2.2 Consented Scheme Comparison

Proposed Elevations - East

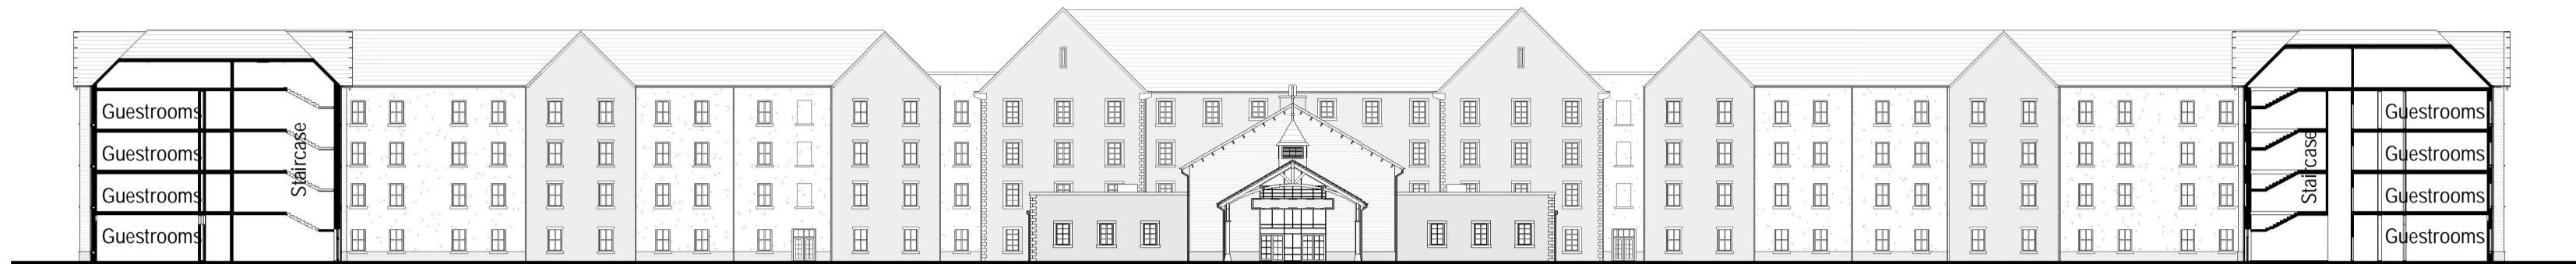
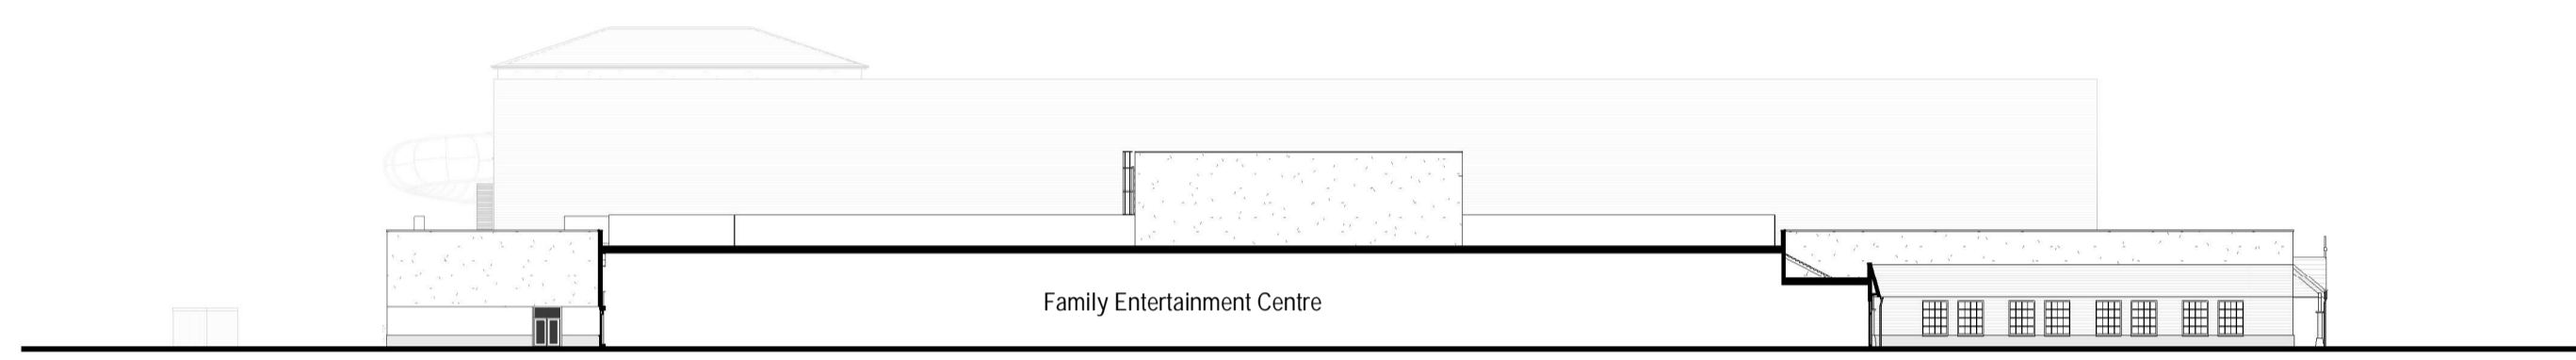
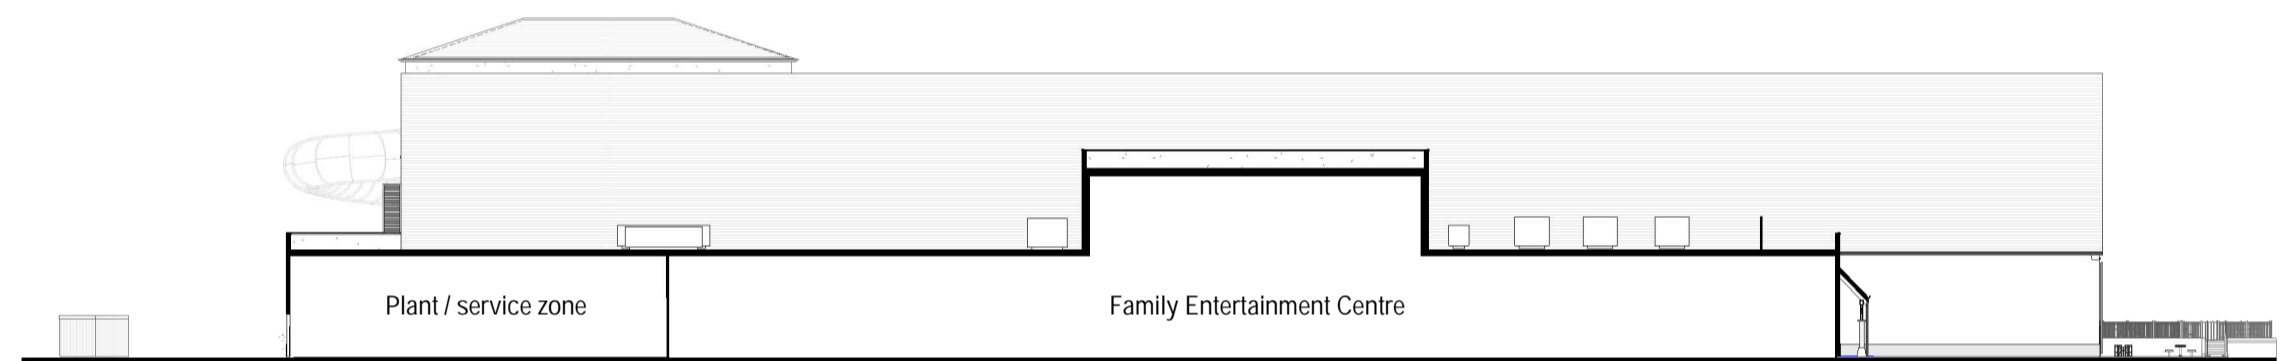
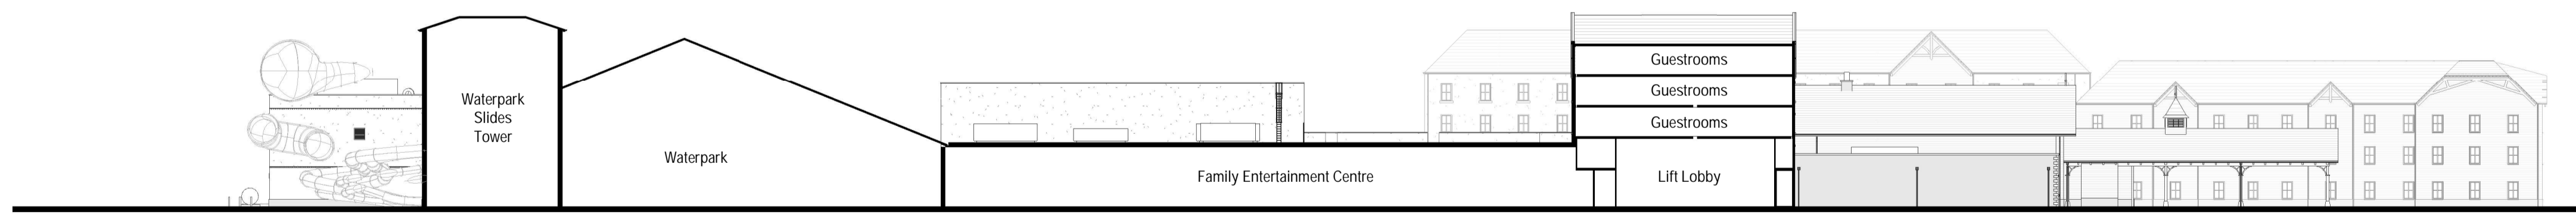
- ① Water slide design updated. The overall height of the waterslide remains below the height of the turret which remains fixed.
- ② Waste compactor rolling shutter and external grille locations updated to suit new compactor room size. External double door omitted due to internal room reconfiguration.

- ① Reduction in the overall size of the FEC resulting in a shift of the guestroom u-shaped tower southwards by approx. 3.6m.
- ② External louvres and integrated doorset omitted from elevation due to internal plant relocation. Relocated along same South-East facade.

Proposed Elevations - North-West

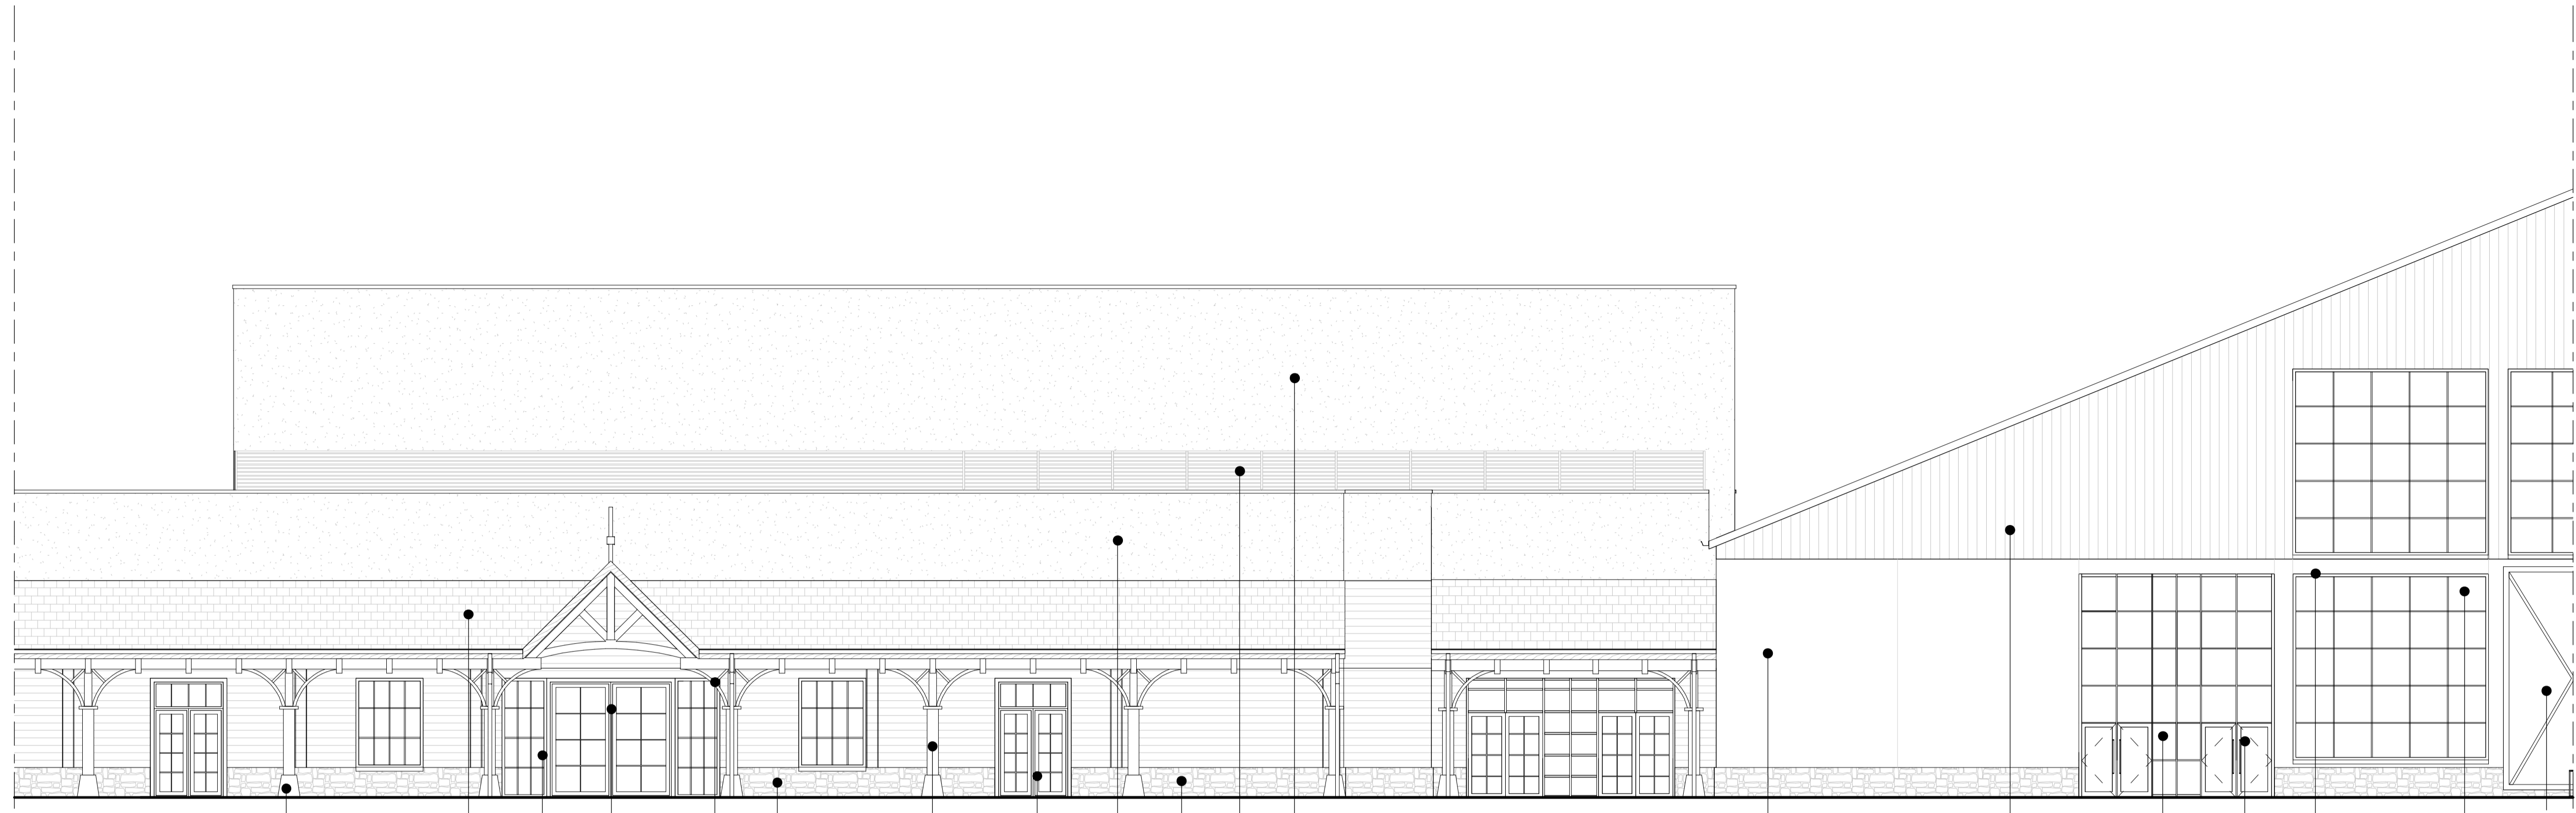
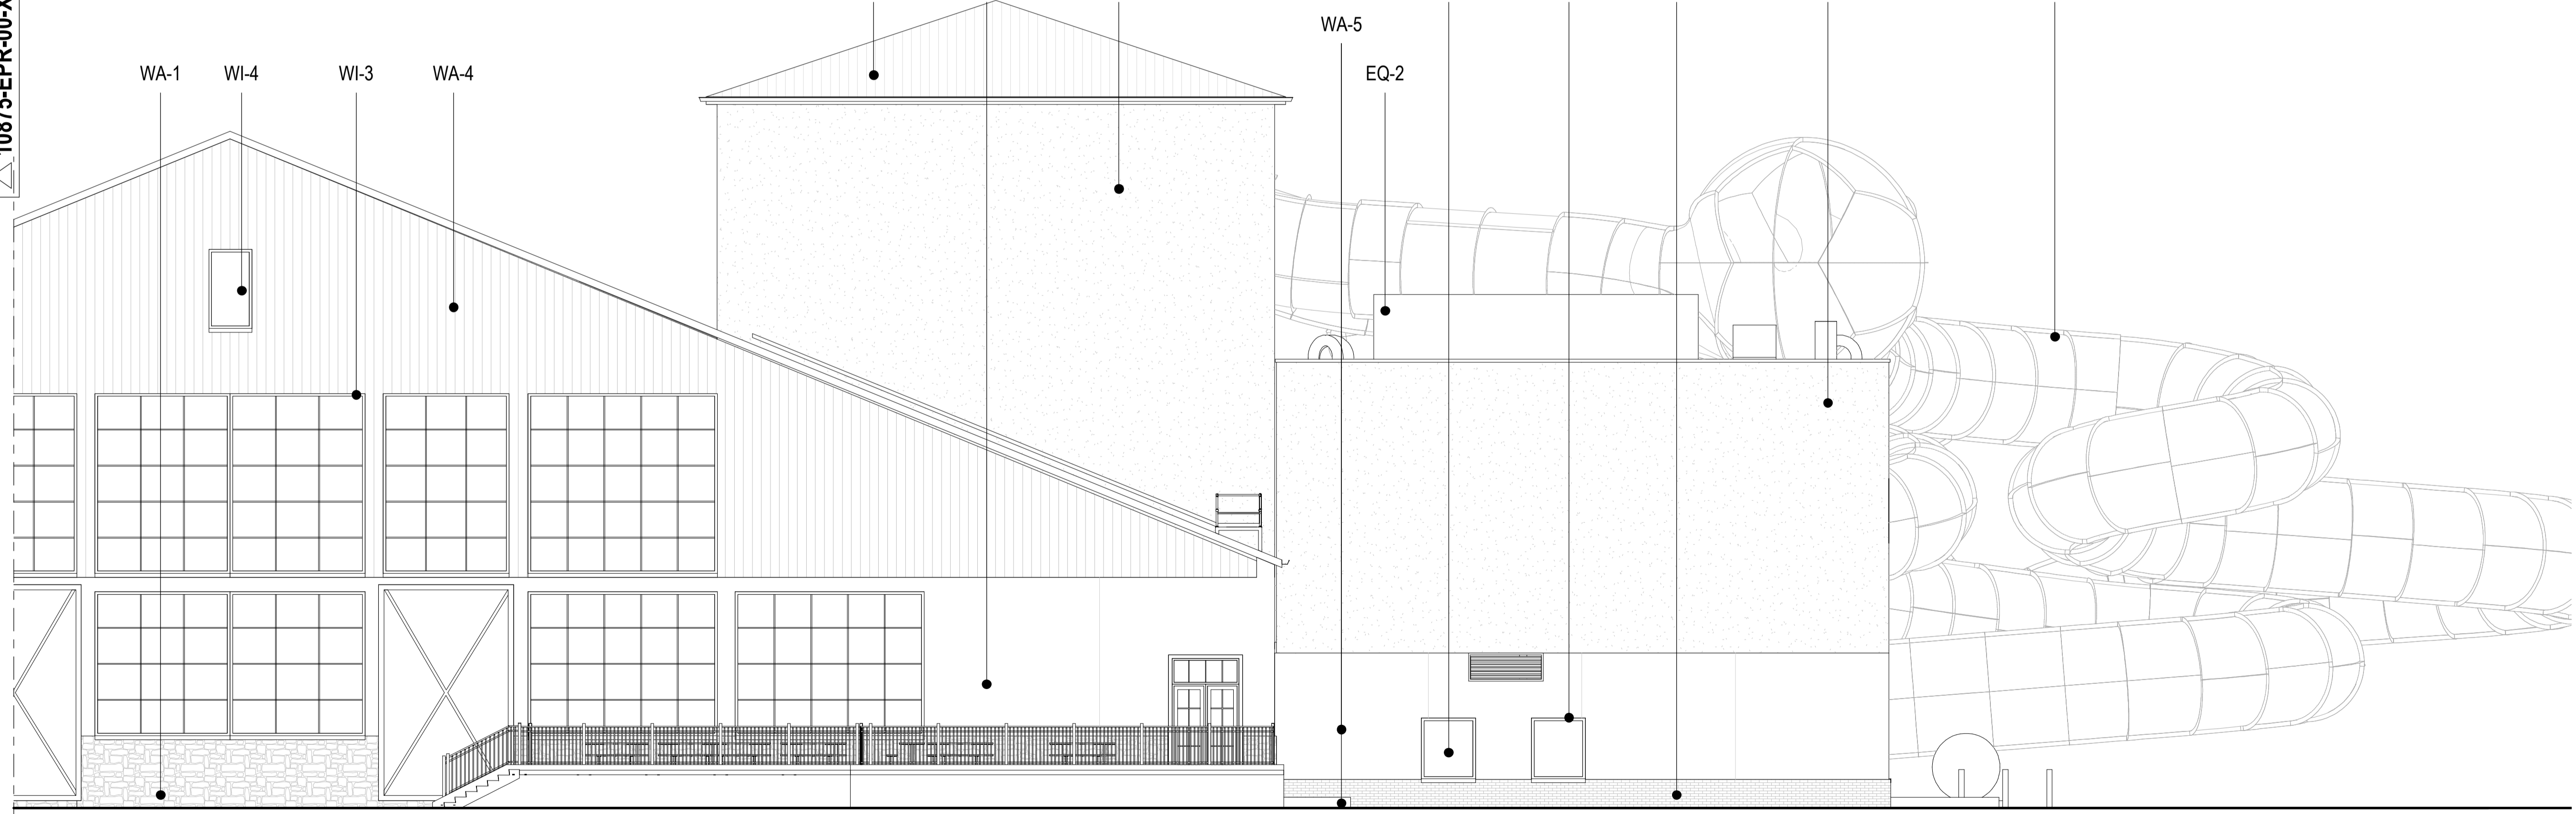
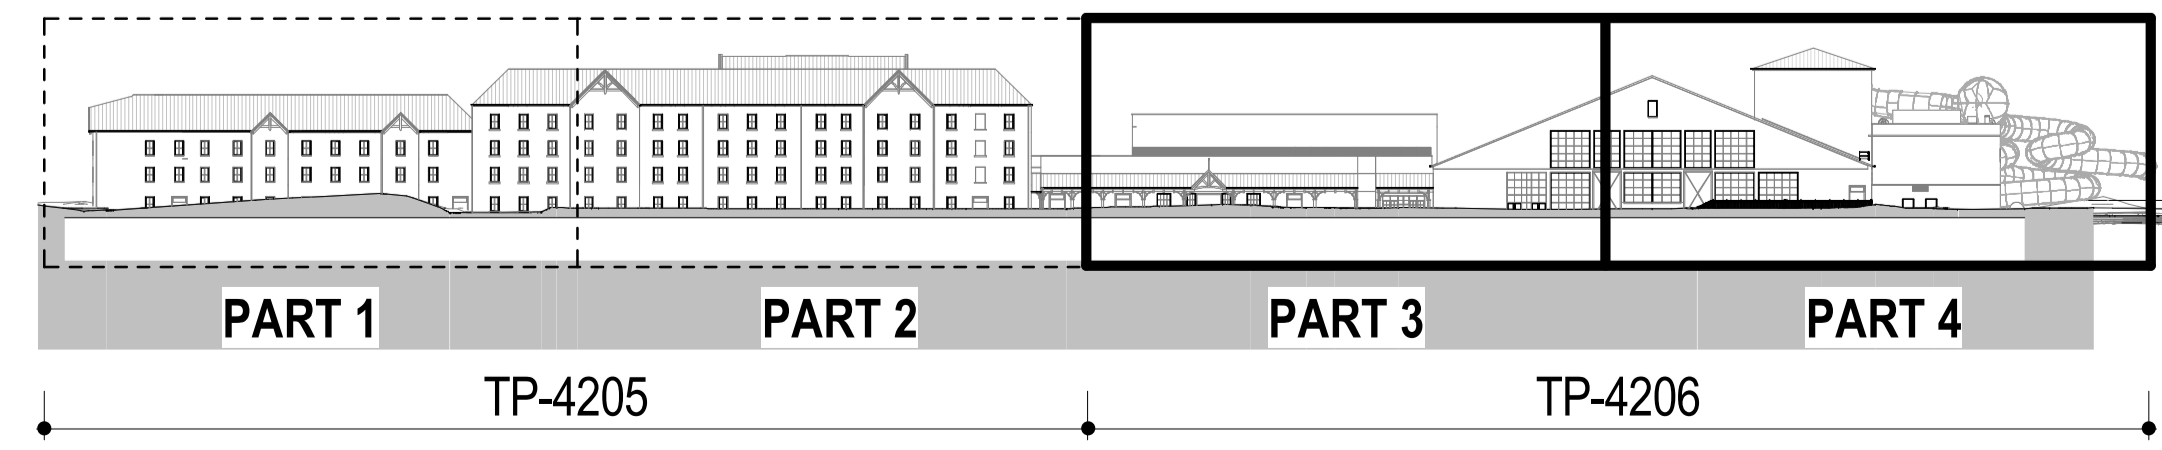
- ① Reduction in the overall size of the FEC resulting in a shift of the guestroom u-shaped tower southwards by approx. 3.6m.
- ② Re-configuration of the conference centre massing, facade design and internal layout.
- ③ Water slide design updated. The overall height of the waterslide remains below the height of the turret which remains fixed.
- ④ Additional door added to create a link from the water park to outdoor terrace.
- ⑤ External water park deck layouts revised and height levels updated to facilitate raised terrace zone with associated balustrade. Enlargened square to the South East corner created to host new outdoor whirlpool design.

- ① Reduction in the overall size of the FEC resulting in a shift of the guestroom u-shaped tower southwards by approx. 3.6m.
- ② Re-configuration of the conference centre massing, facade design and internal layout.
- ③ Omission of bridge link above FEC roof for access and maintenance.
